Recommendation Report for Planning Permission for Works or Extension to a Dwelling

REF NO: BE/51/21/HH

LOCATION: 59 Mansfield Road
Bersted
PO22 9HA

PROPOSAL: Removal of existing conservatory and erection of single storey rear extension.

sheet 1 of 2

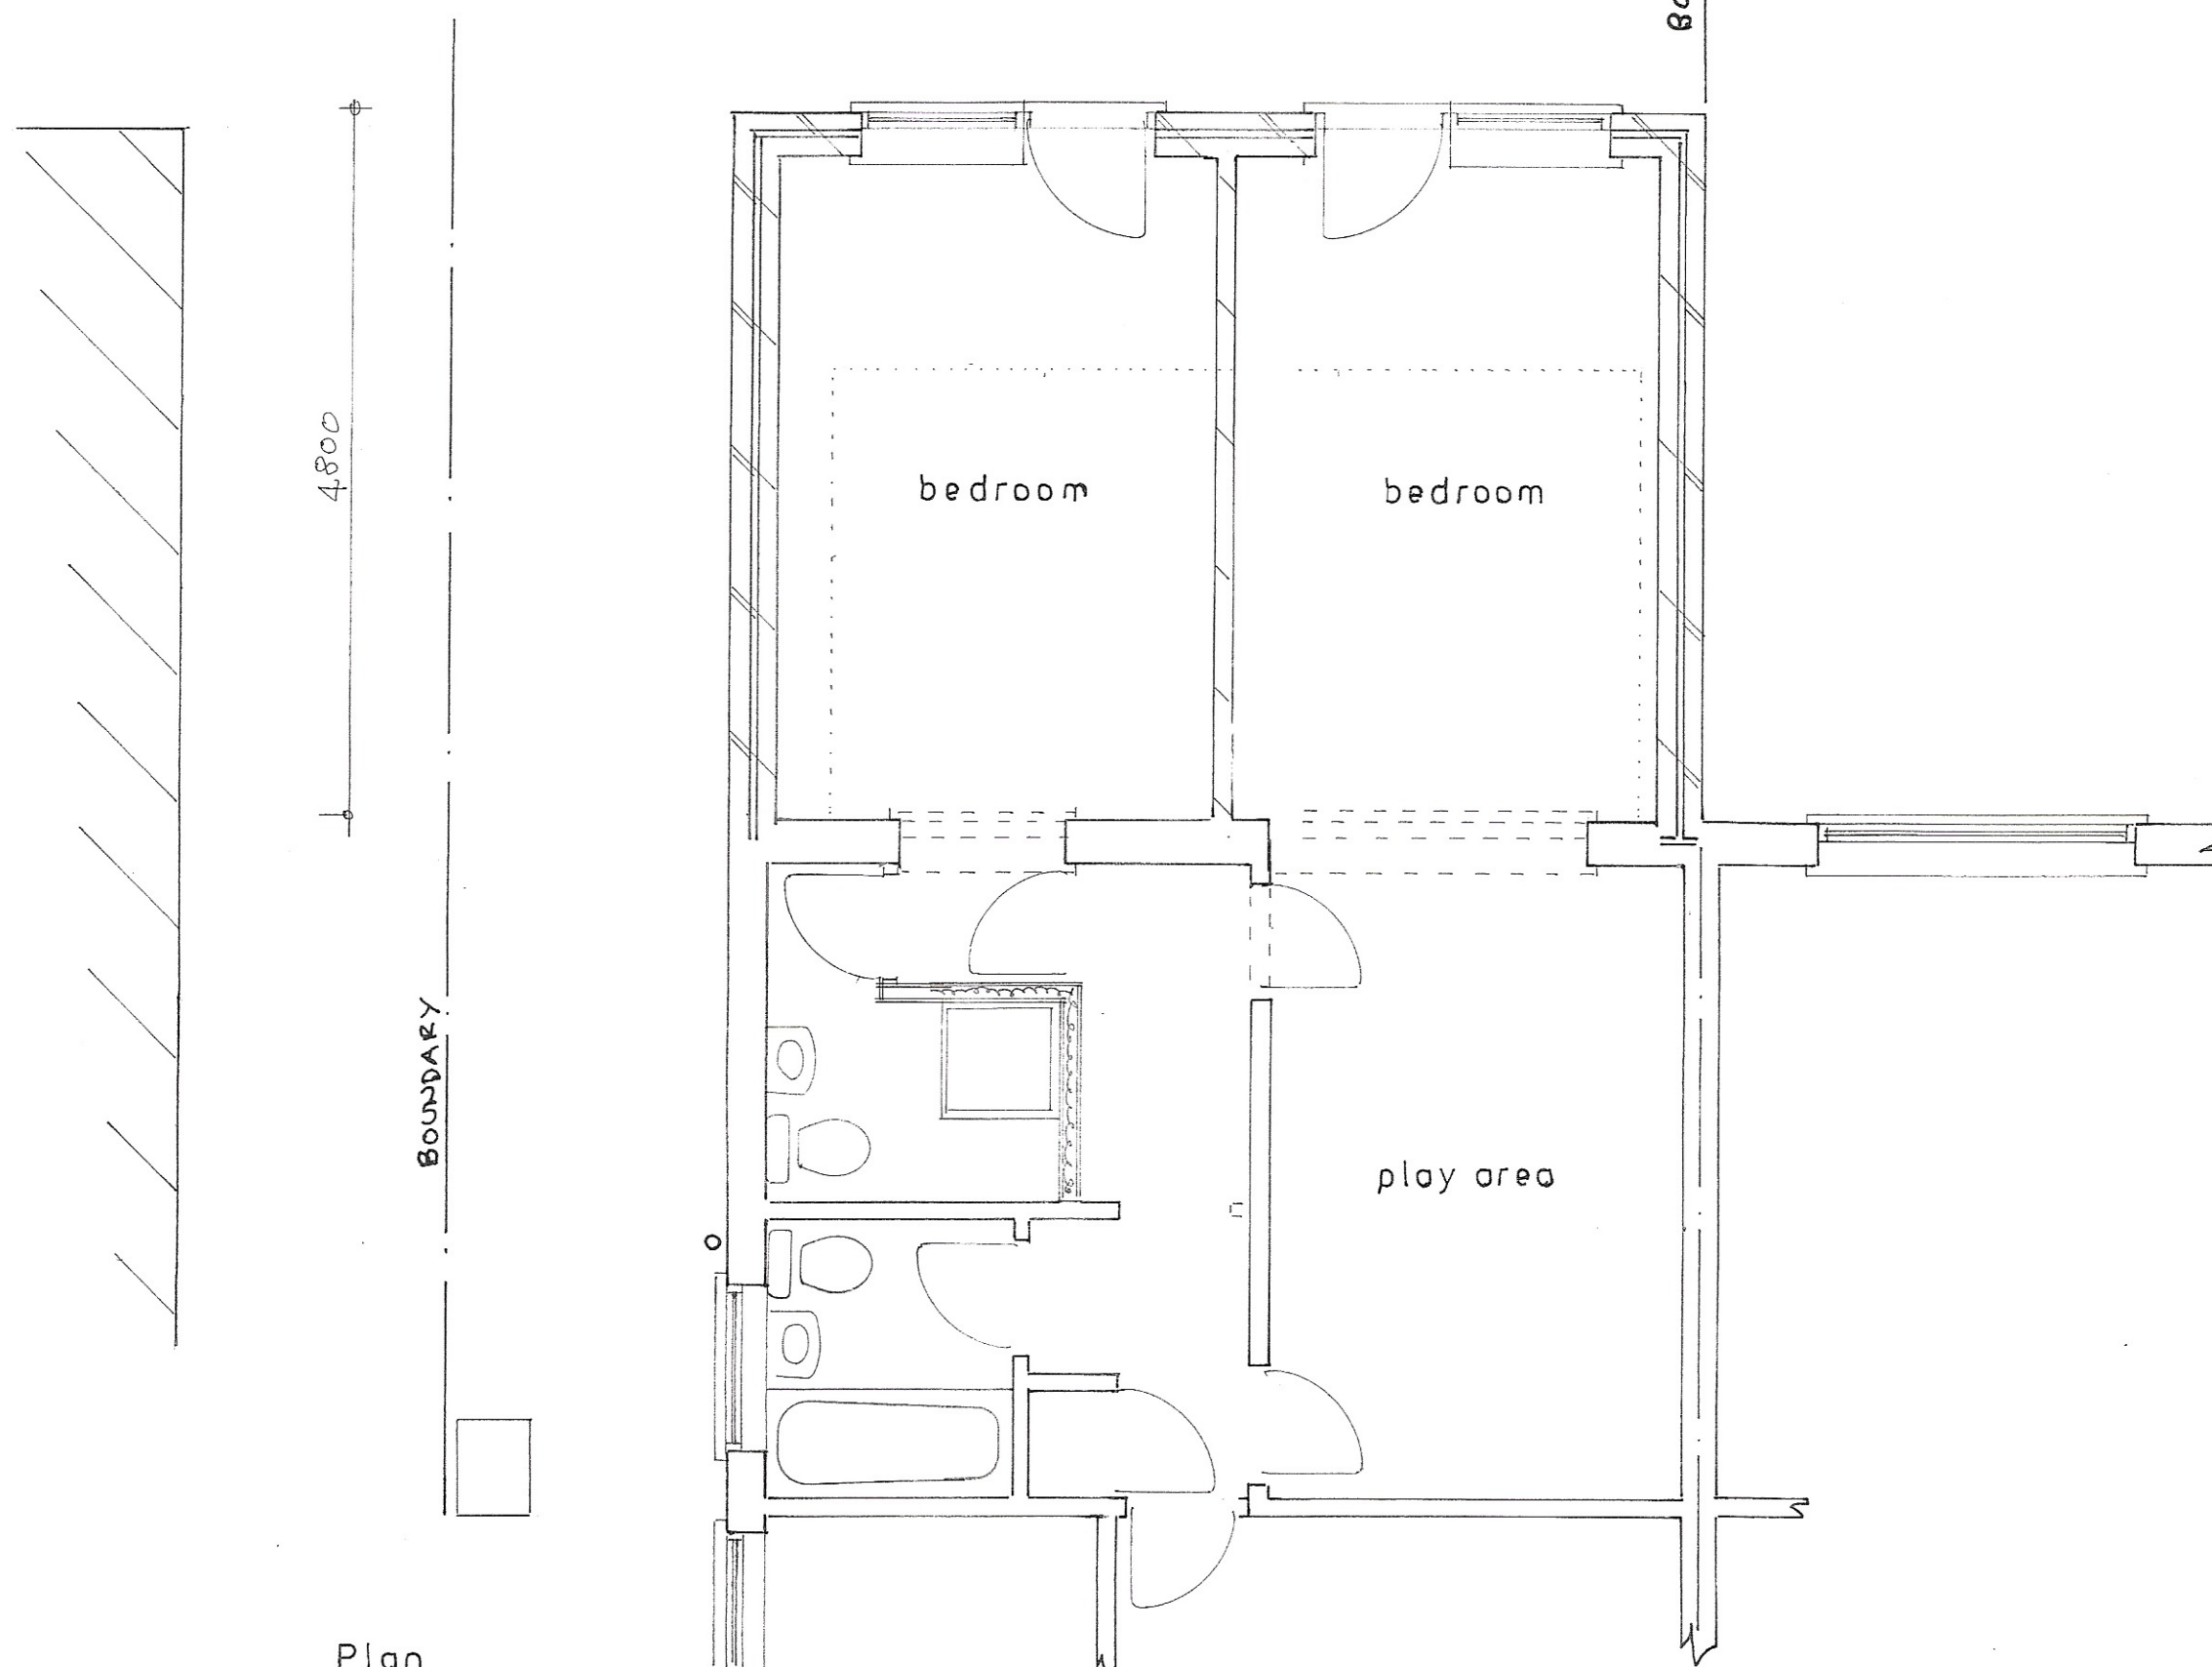
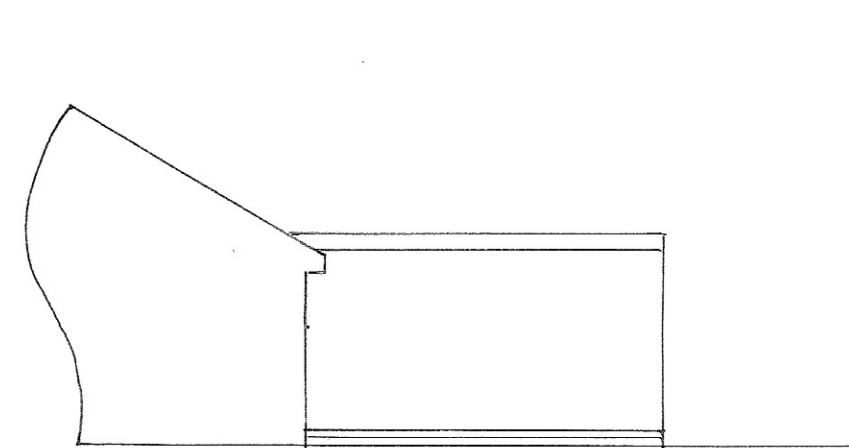
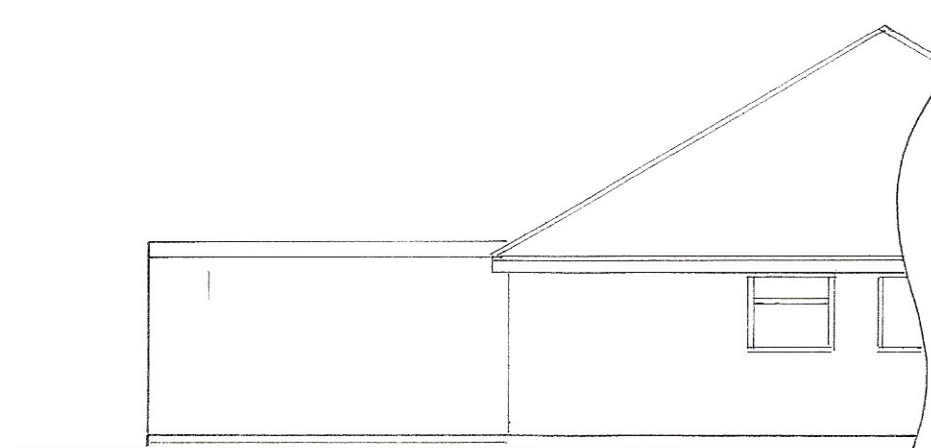
There is a conservatory with a depth of 3m which will be removed and replaced with an extension 4.8m in depth. It will have a flat roof, meeting with the eaves of the host dwelling which is a bungalow.

The extension will have a depth of 4.8m and is modest in height at 2.7m.

The Council uses a 45 degree rule to assess serious effects on neighbouring properties. The proposed development due to its siting, intersects a 45 degree angle when drawn from the centre of the ground floor rear window at the neighbouring property at No.61. However, an extension could be constructed up to this depth under prior approval with no objections from the neighbours and with no representation received, the development is considered acceptable.

It is noted the existing conservatory breaches this also and with boundary treatment in place which could be up to 2m in height, the extension is not considered significantly harmful to the amenity of the adjoining occupiers to the north.
